**KIRKLEES METROPOLITAN COUNCIL
INVESTMENT & REGENERATION SERVICE**

**DELEGATED DECISION TO DETERMINE APPLICATIONS FOR
CONSENT, AGREEMENT OR APPROVAL REQUIRED BY CONDITION**

Reference No:	2024/44/93593/E
Site Address:	adj, Listing Mill Farm, Listing Lane, Gomersal, Cleckheaton, BD19 4HS
Description:	Discharge of details reserved by conditions 6 (Phase II Report), 10 (nest box), 11 (boundary treatments) and 12 (bin storage and collection) on previous permission 2023/93038 for demolition of existing building and erection of detached dwelling
Recommending Officer:	Elenya Jackson

SITE PLAN

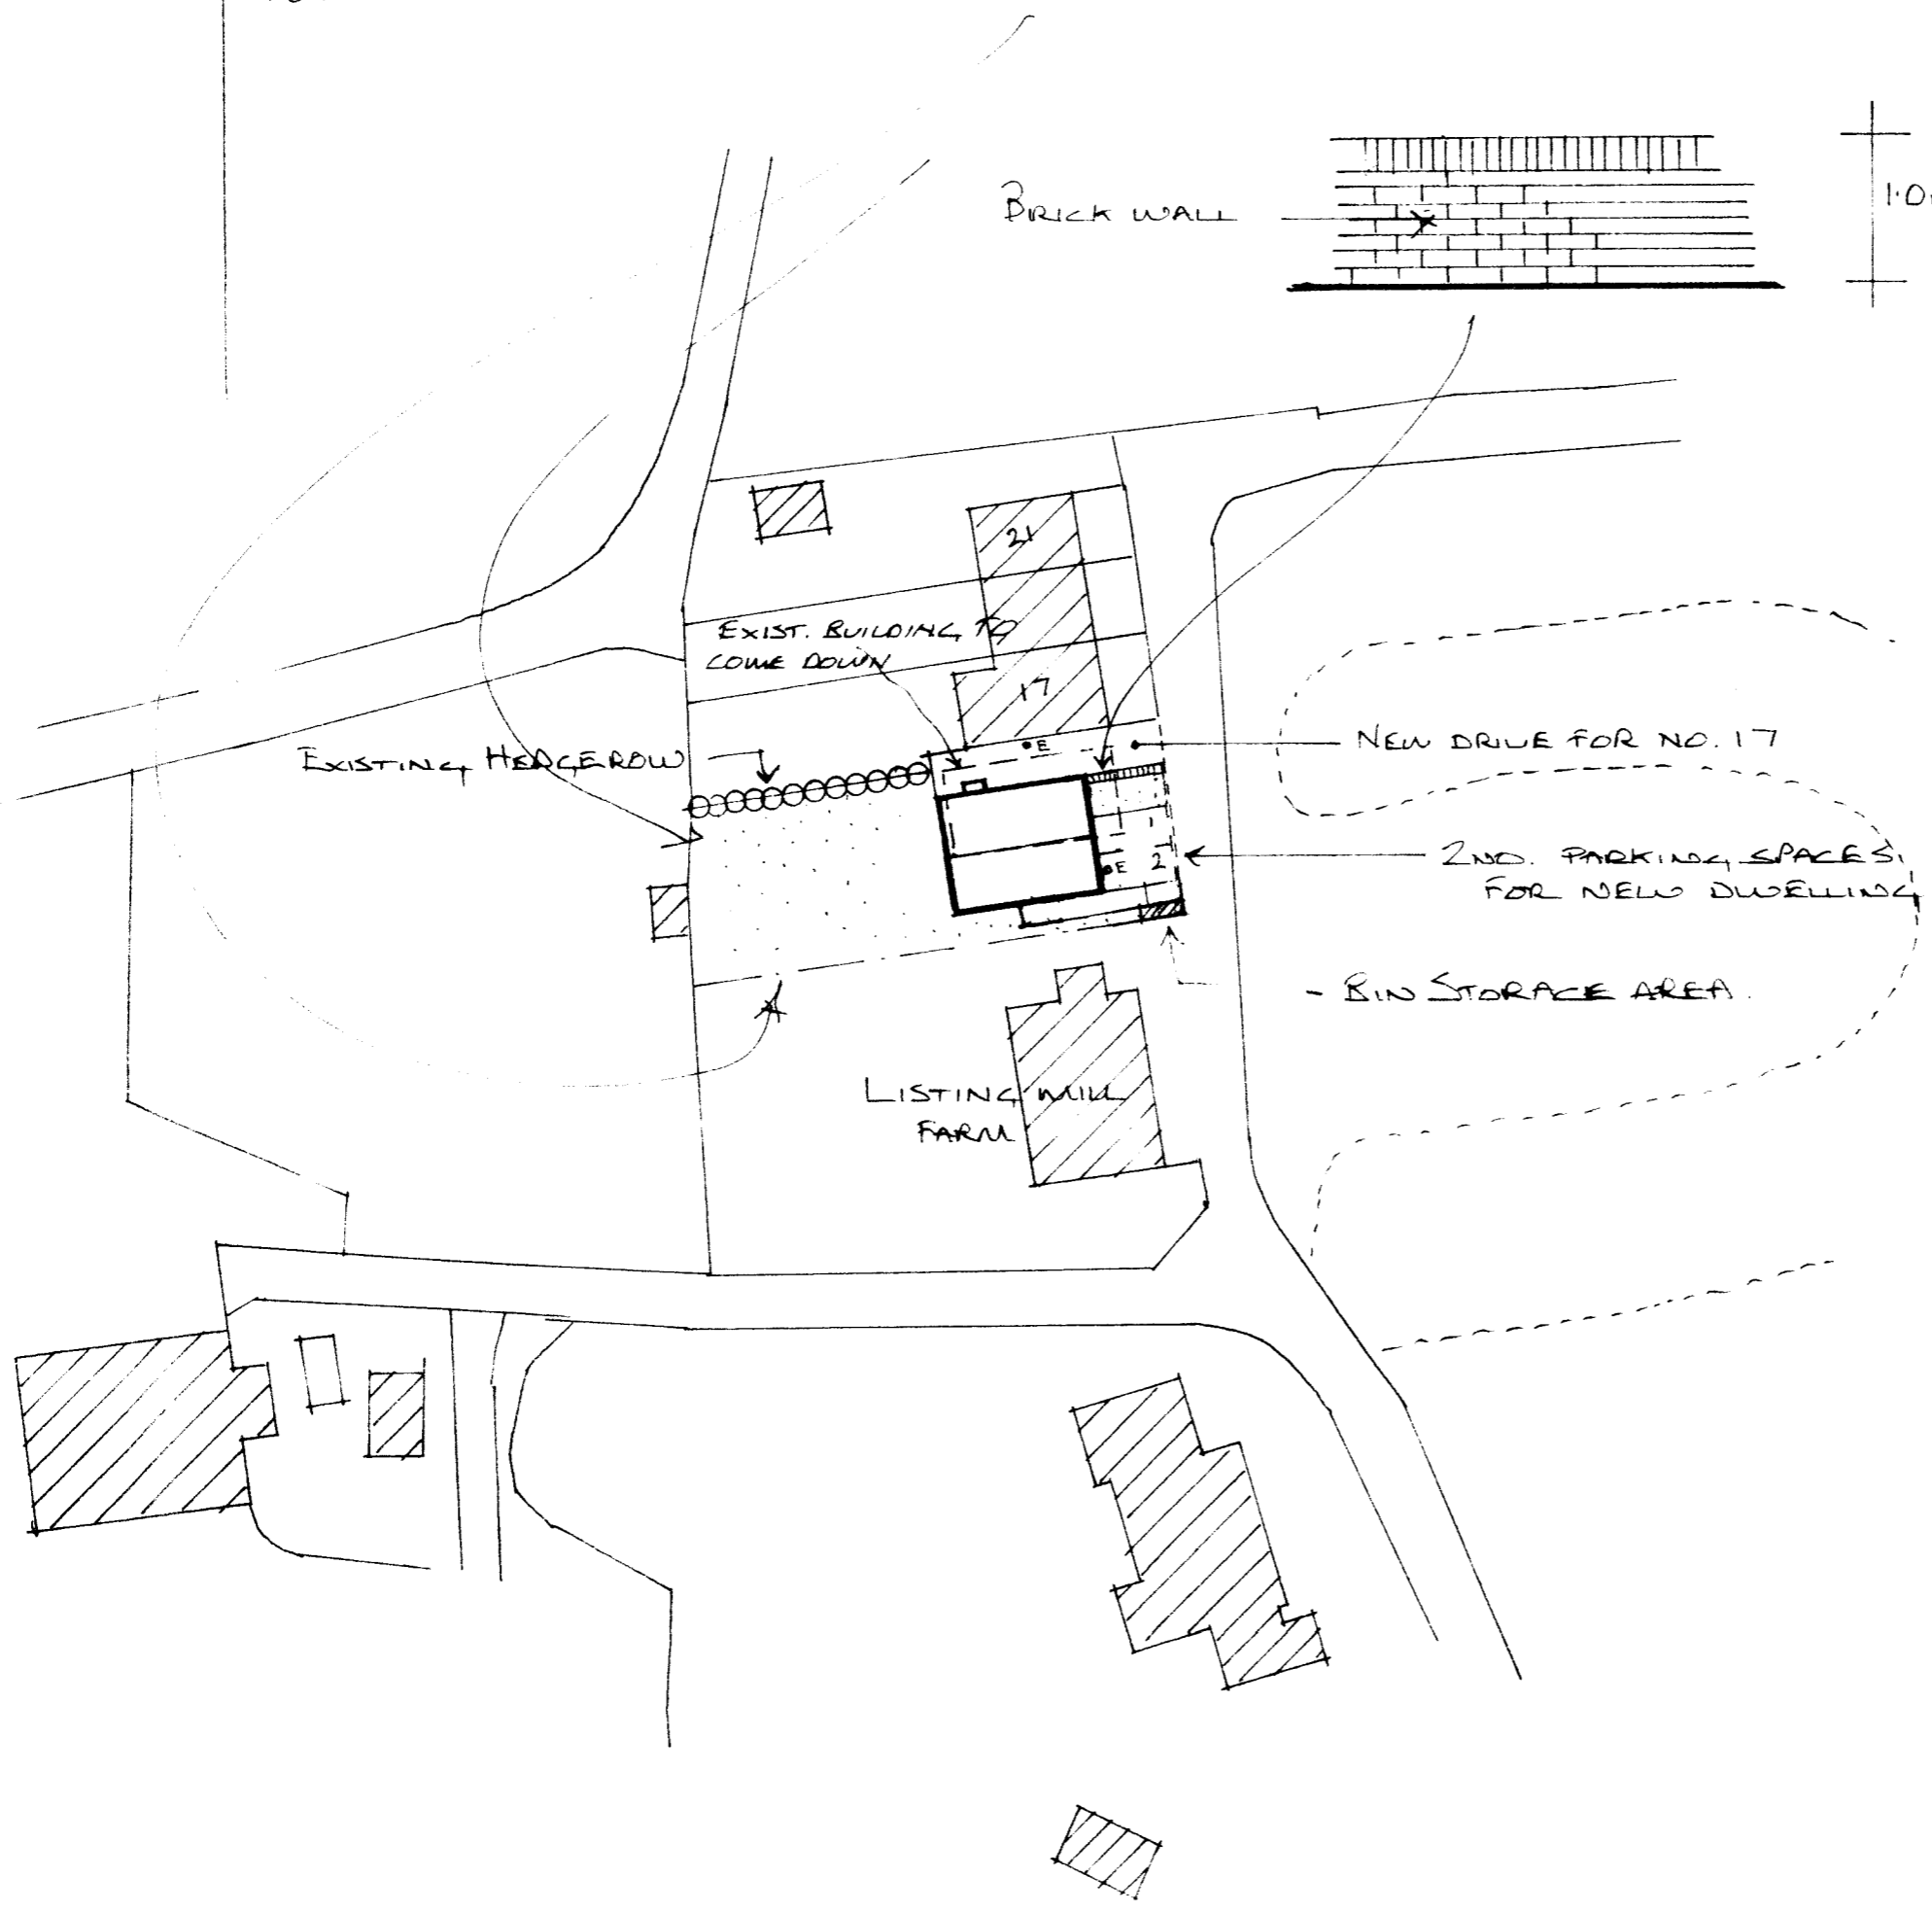
The submitted plans indicate that there would be a timber fence in the rear garden dividing the two properties and a brick wall to the front of the dwelling with a maximum height of 1m.

This shows the location of bin storage being along the southern boundary. The location of bin collection has not been specified; however, it is considered that the bins would be an appropriate distance from the highway.

The details are considered acceptable and condition 11 can therefore be discharged.

The details provided are considered acceptable and condition 12 can therefore be discharged.

Drawing Title
 PROPOSED TWO BED
 DETACHED BUNGALOW

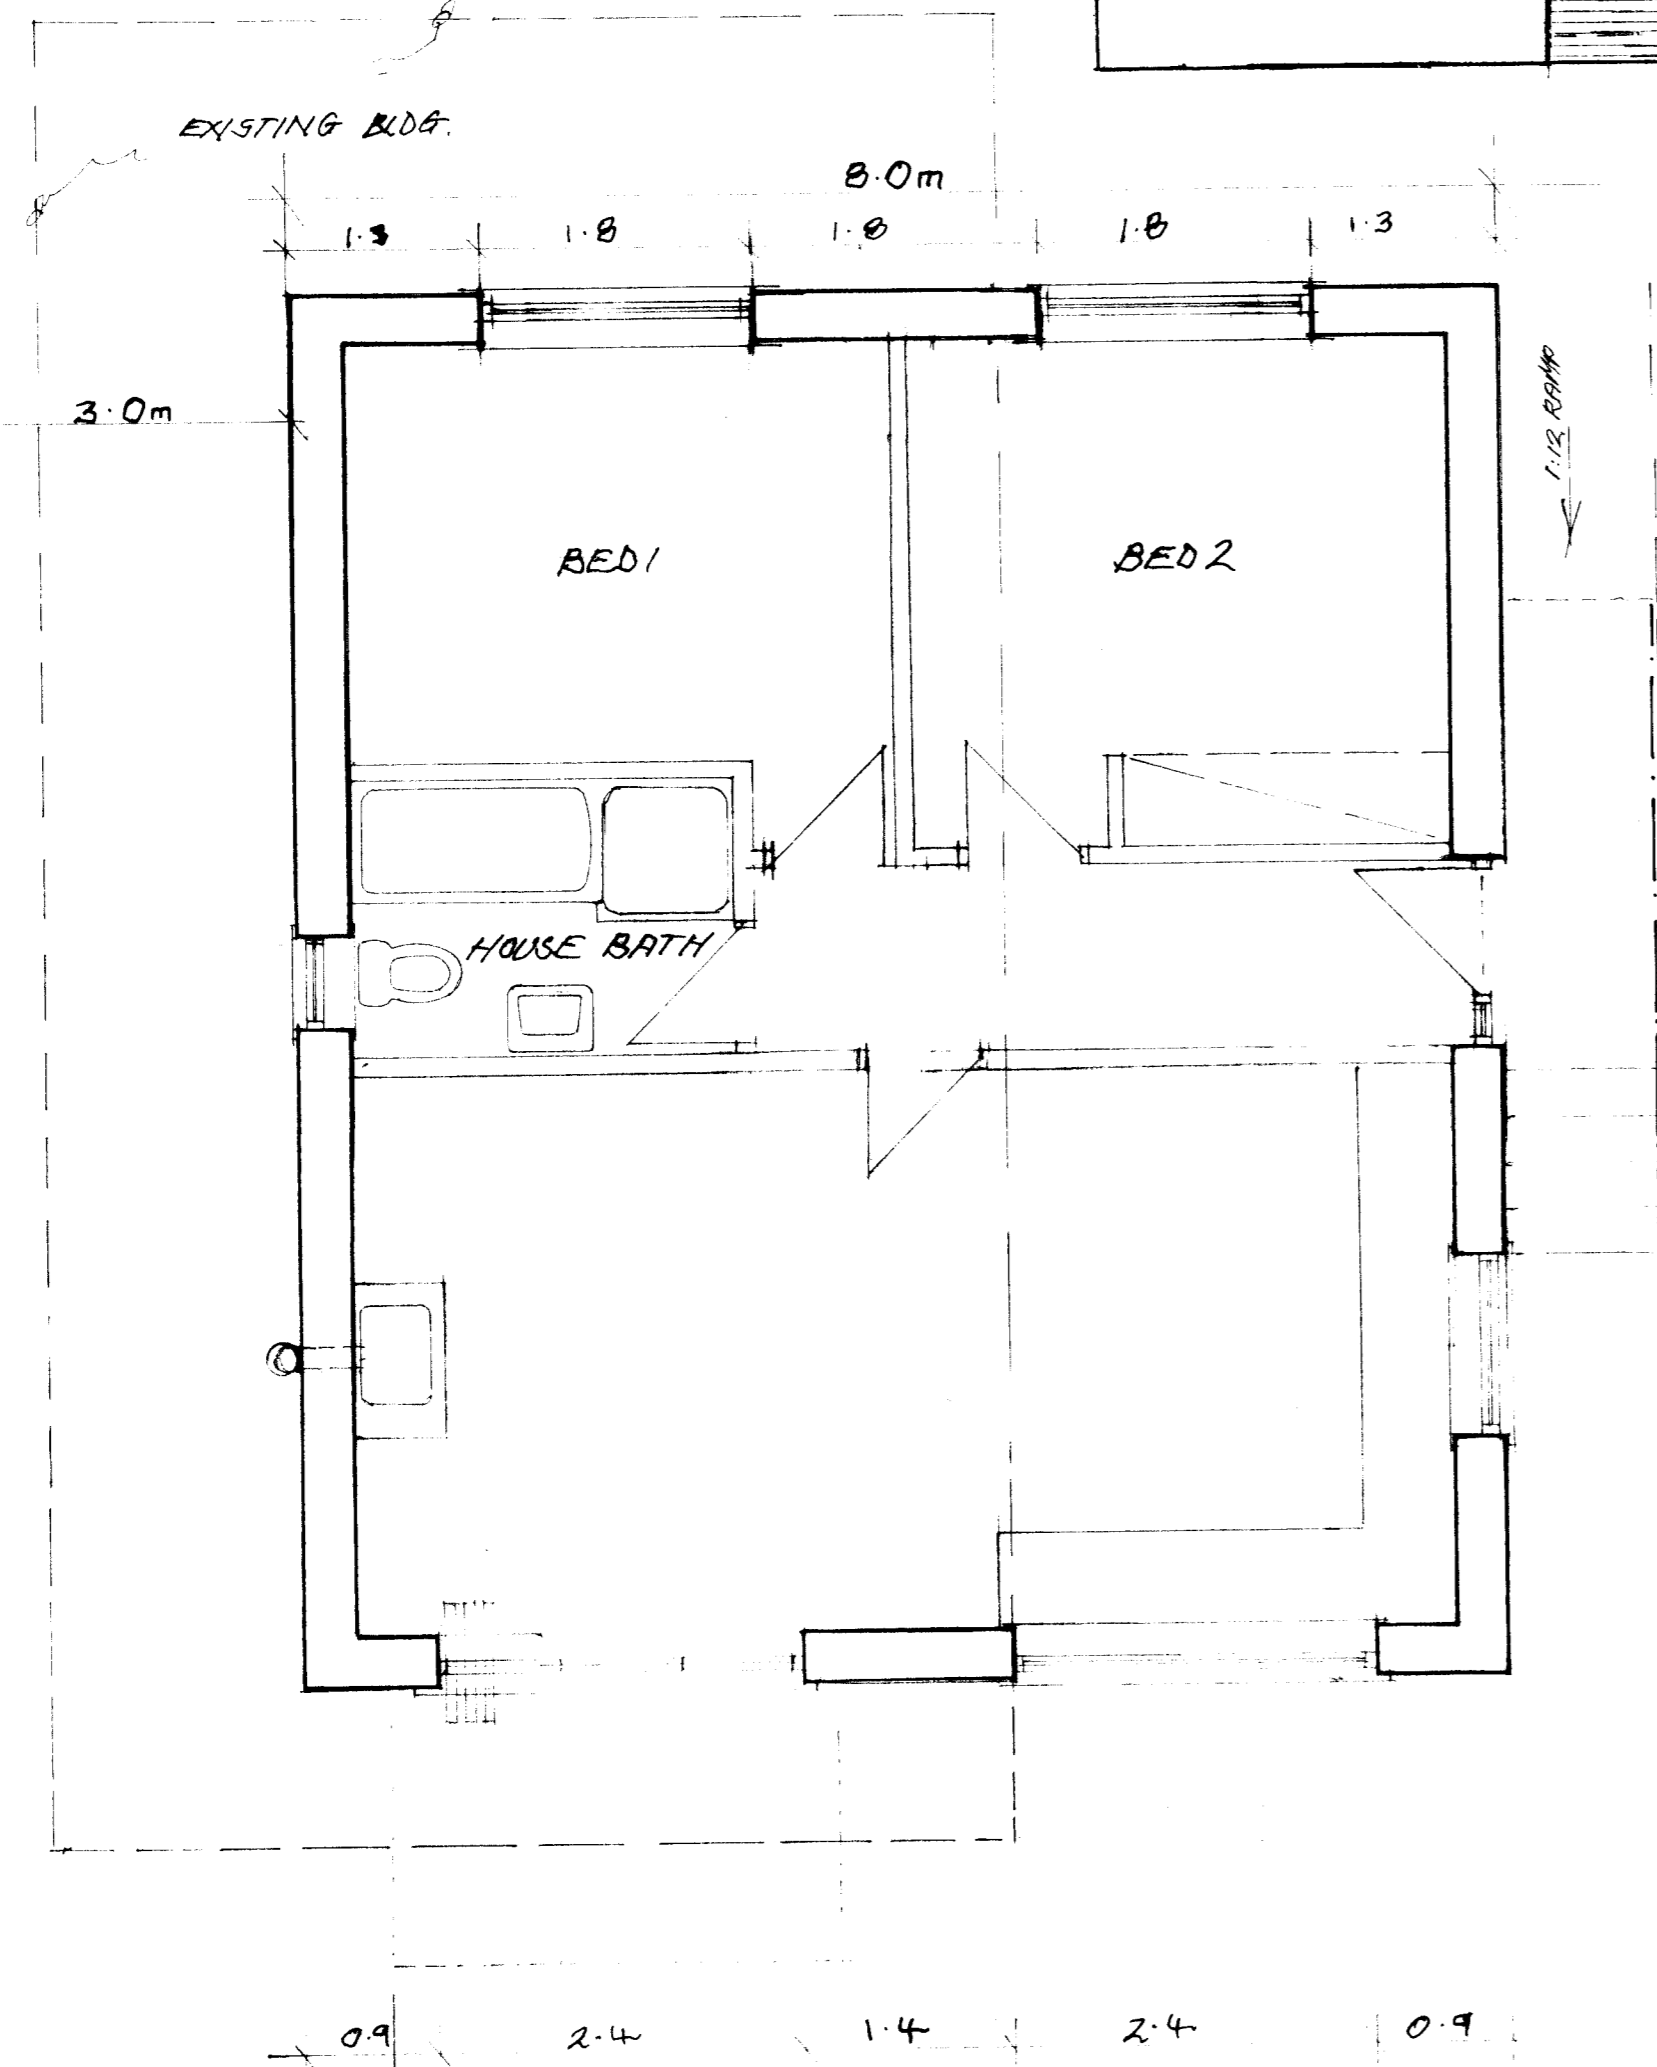
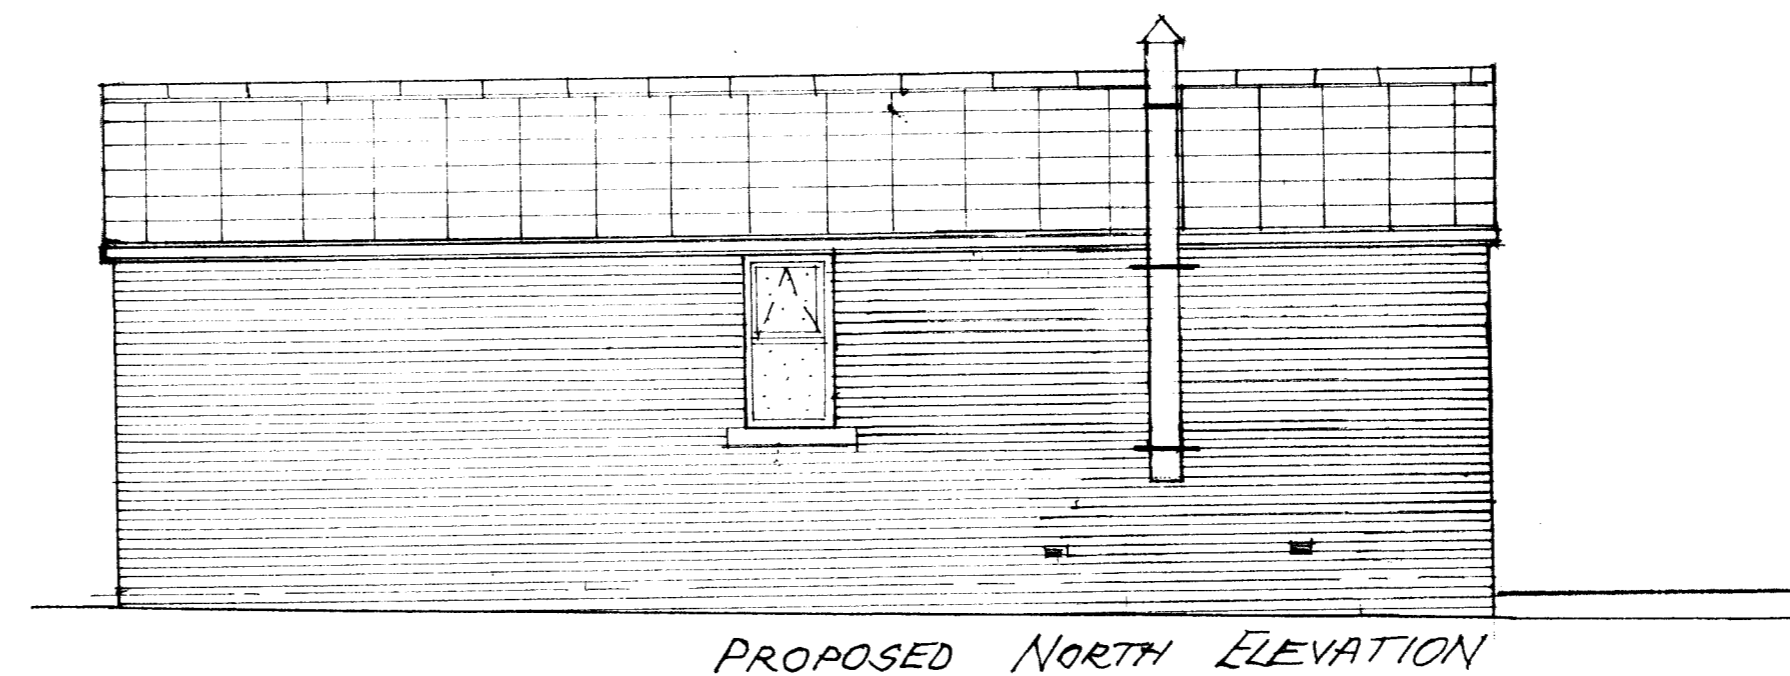
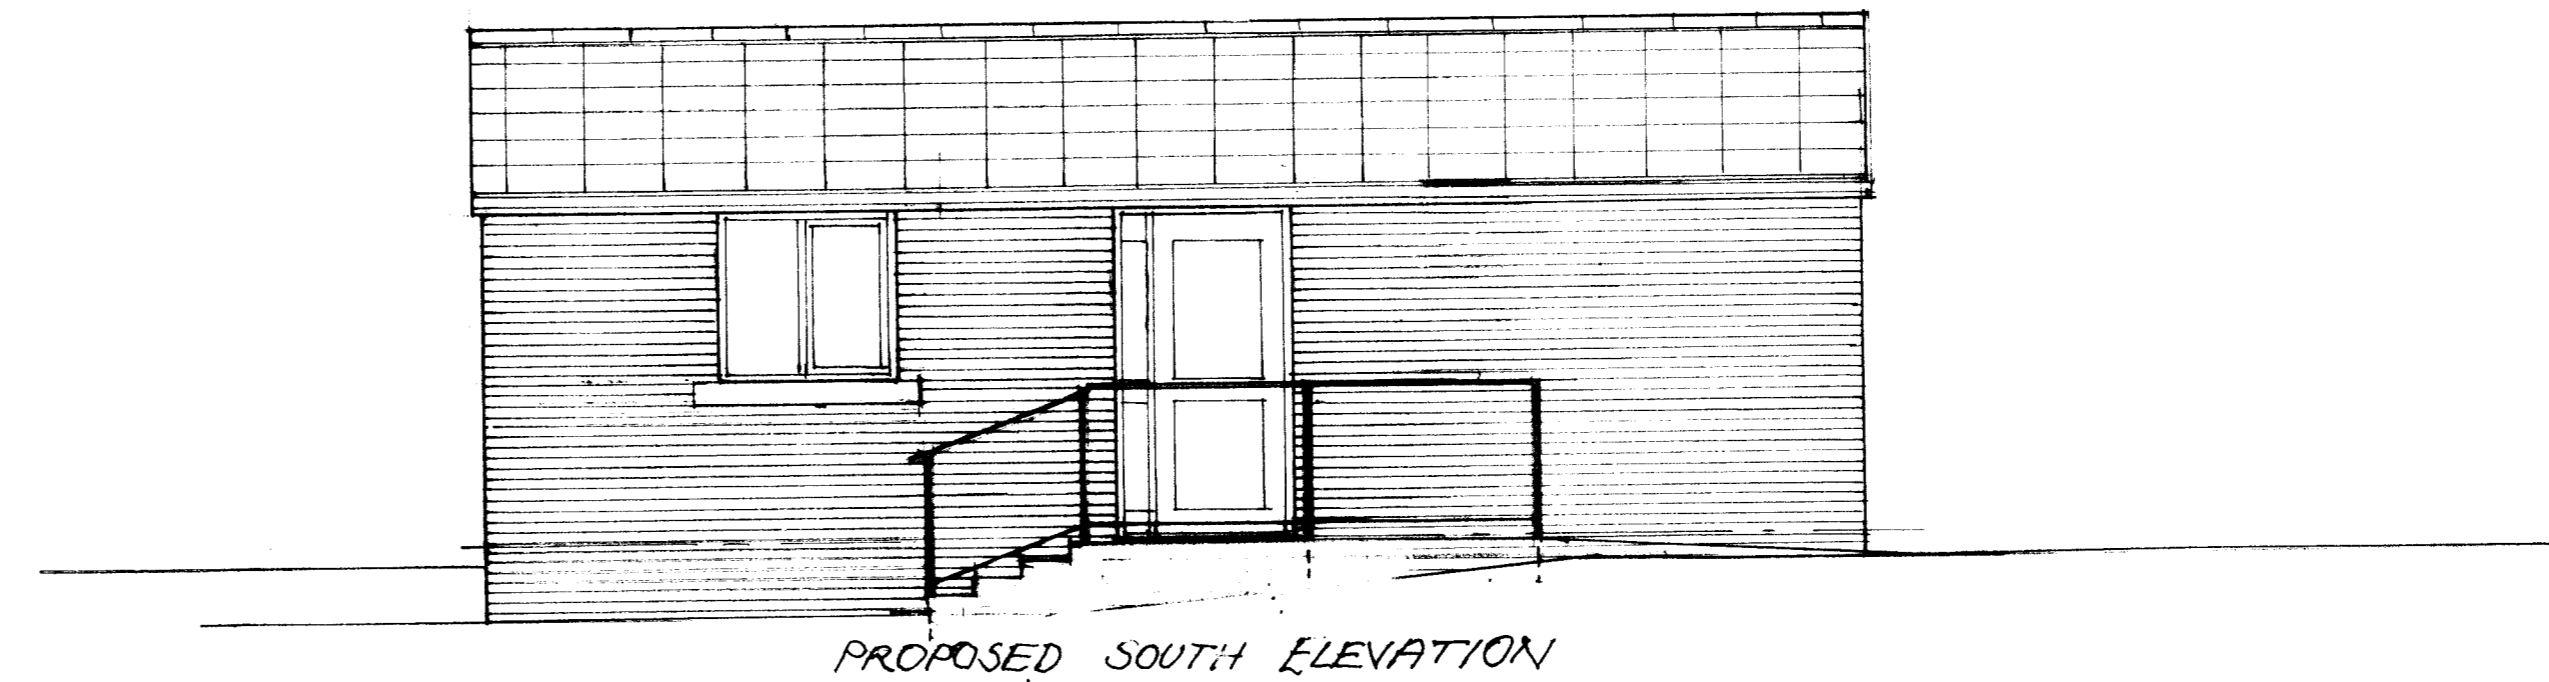
The submitted details demonstrate the location of a sparrow terrace on the principal elevation of the dwelling.

It is considered that the details are appropriate in this instance however this is on the proviso that they should be retained for the lifetime of the development.
